Rezoning Transportation Analysis

Petition Number: 2023-121

Date	Description
10-25-23	First Review (JP)
12-05-23	Second Review (JP)

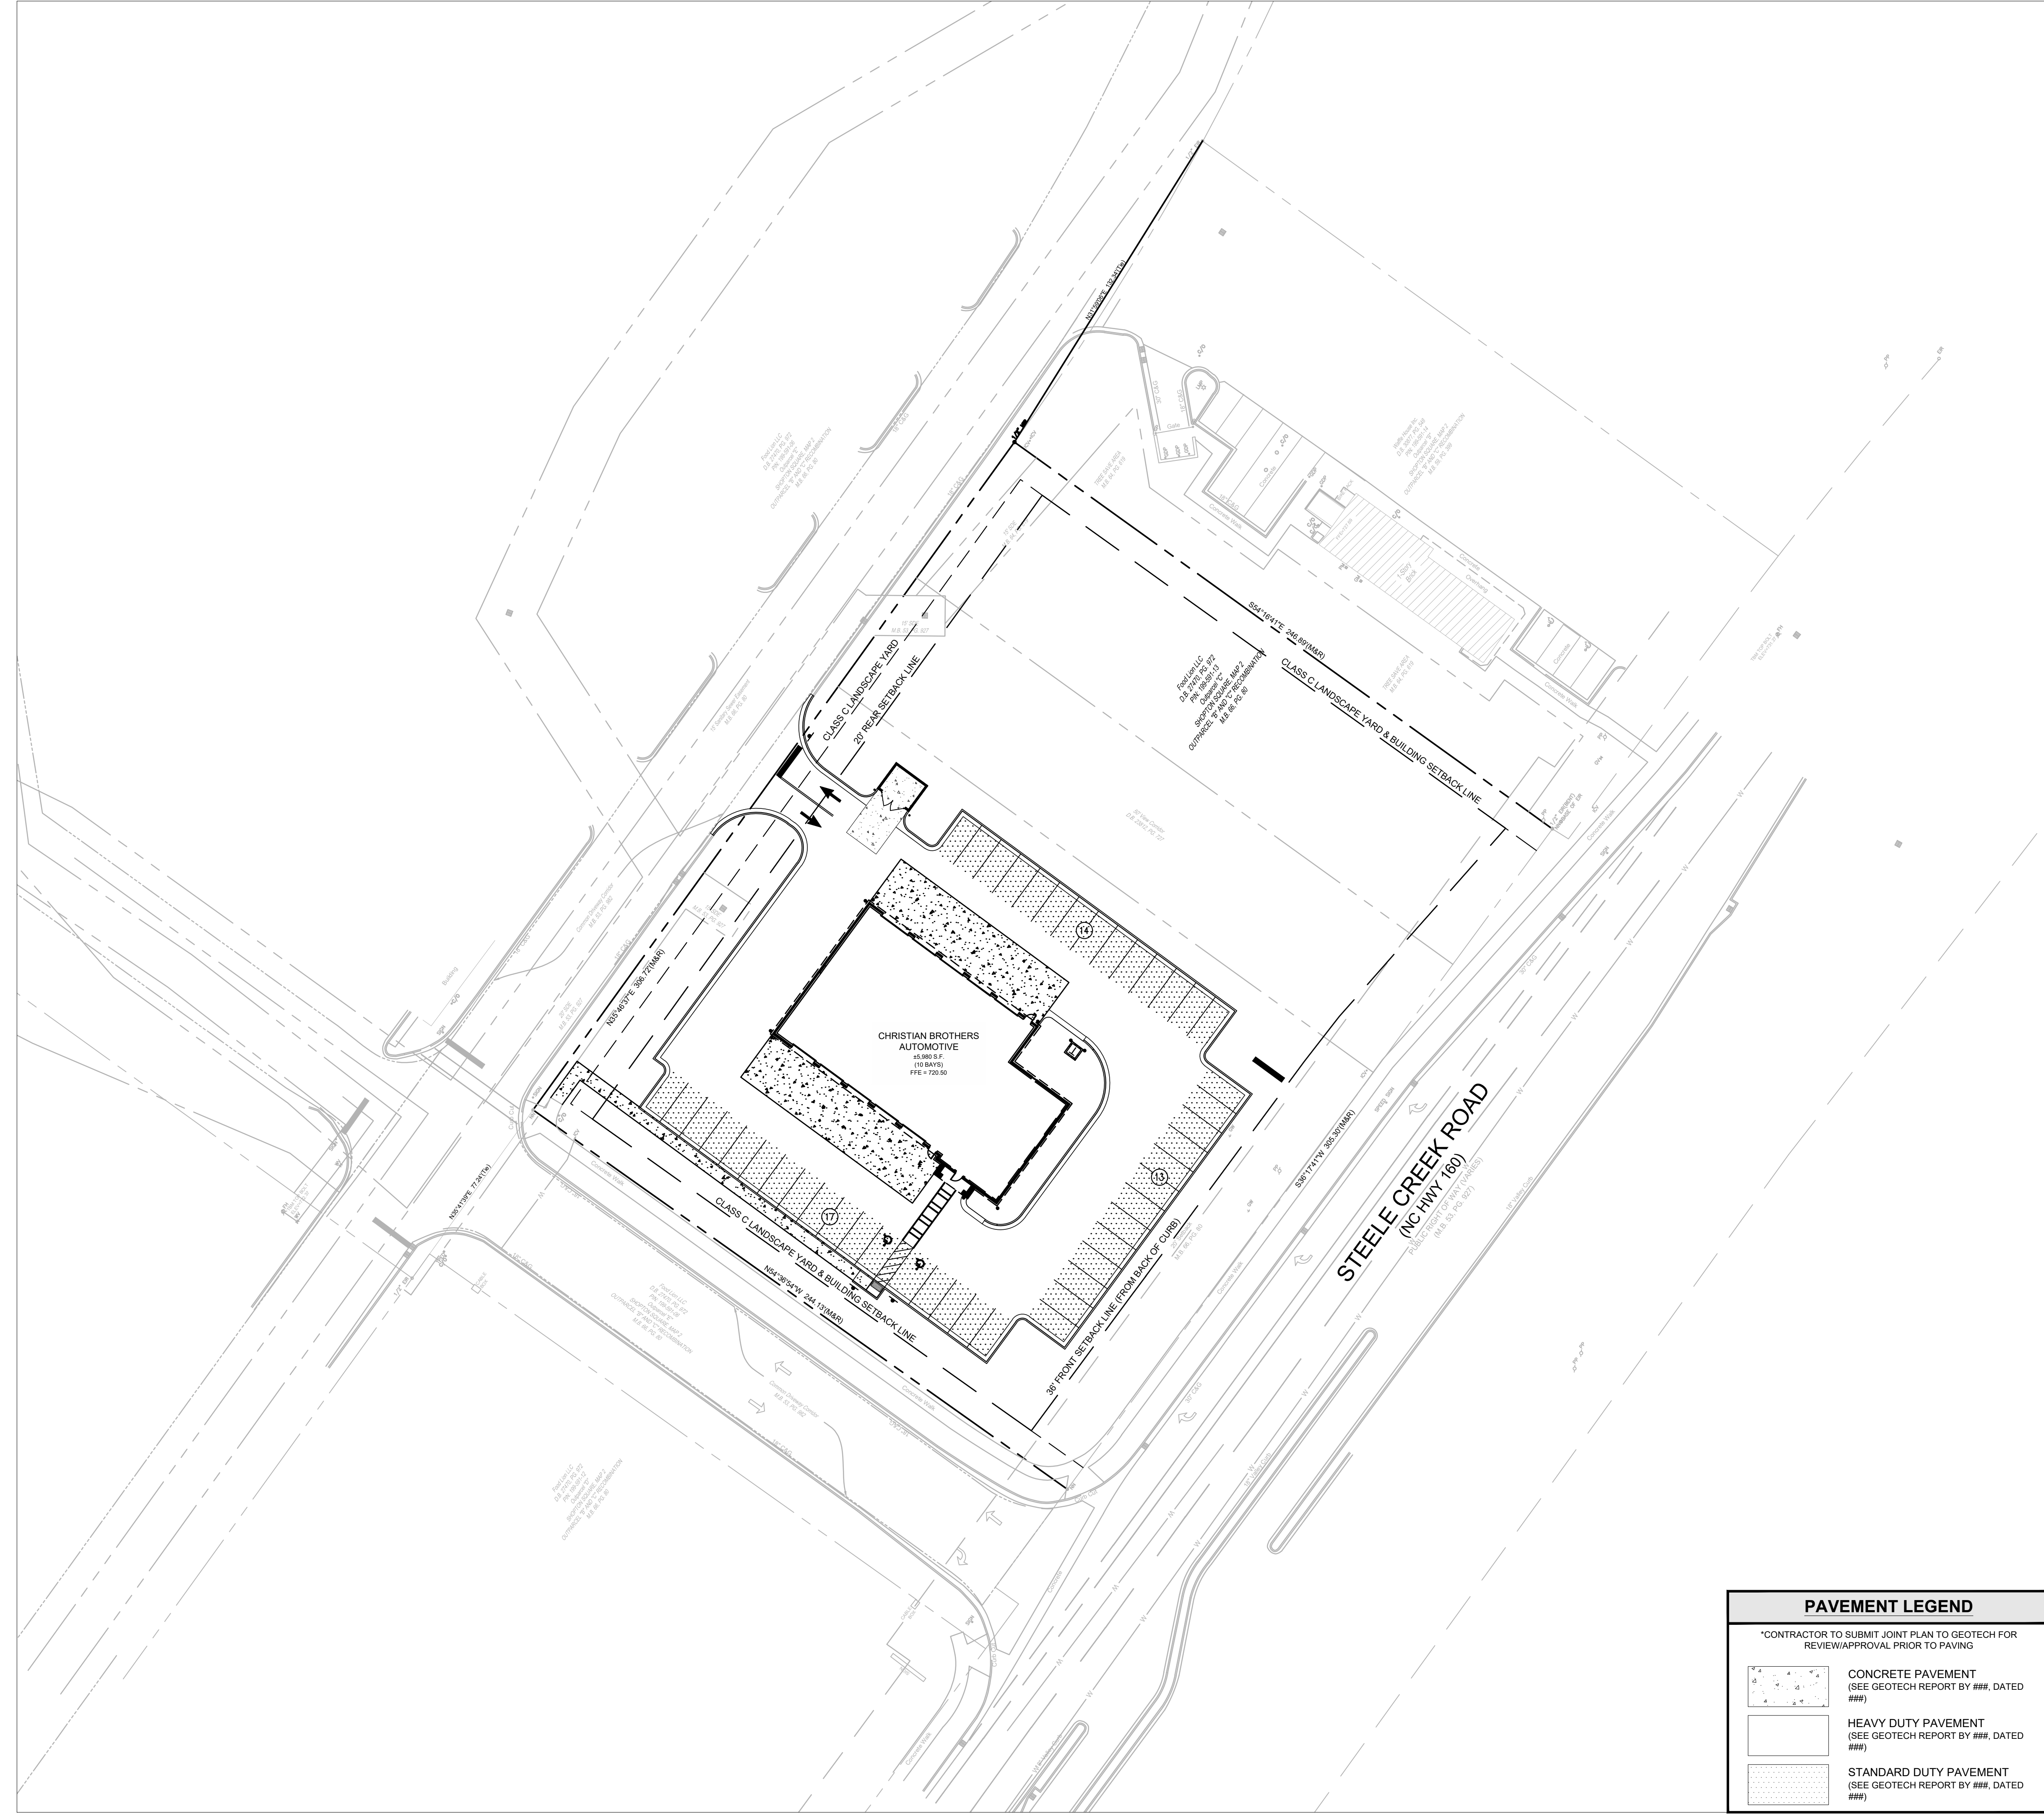
1. Comprehensive Transportation Review (CTR):

A Comprehensive Transportation Review (CTR) is not necessary for the complete review of this petition. If during the permitting process the site generates the designated number of trips outlined on Table 3.1 in the Charlotte Streets Manual, then a Comprehensive Transportation Review will be required.
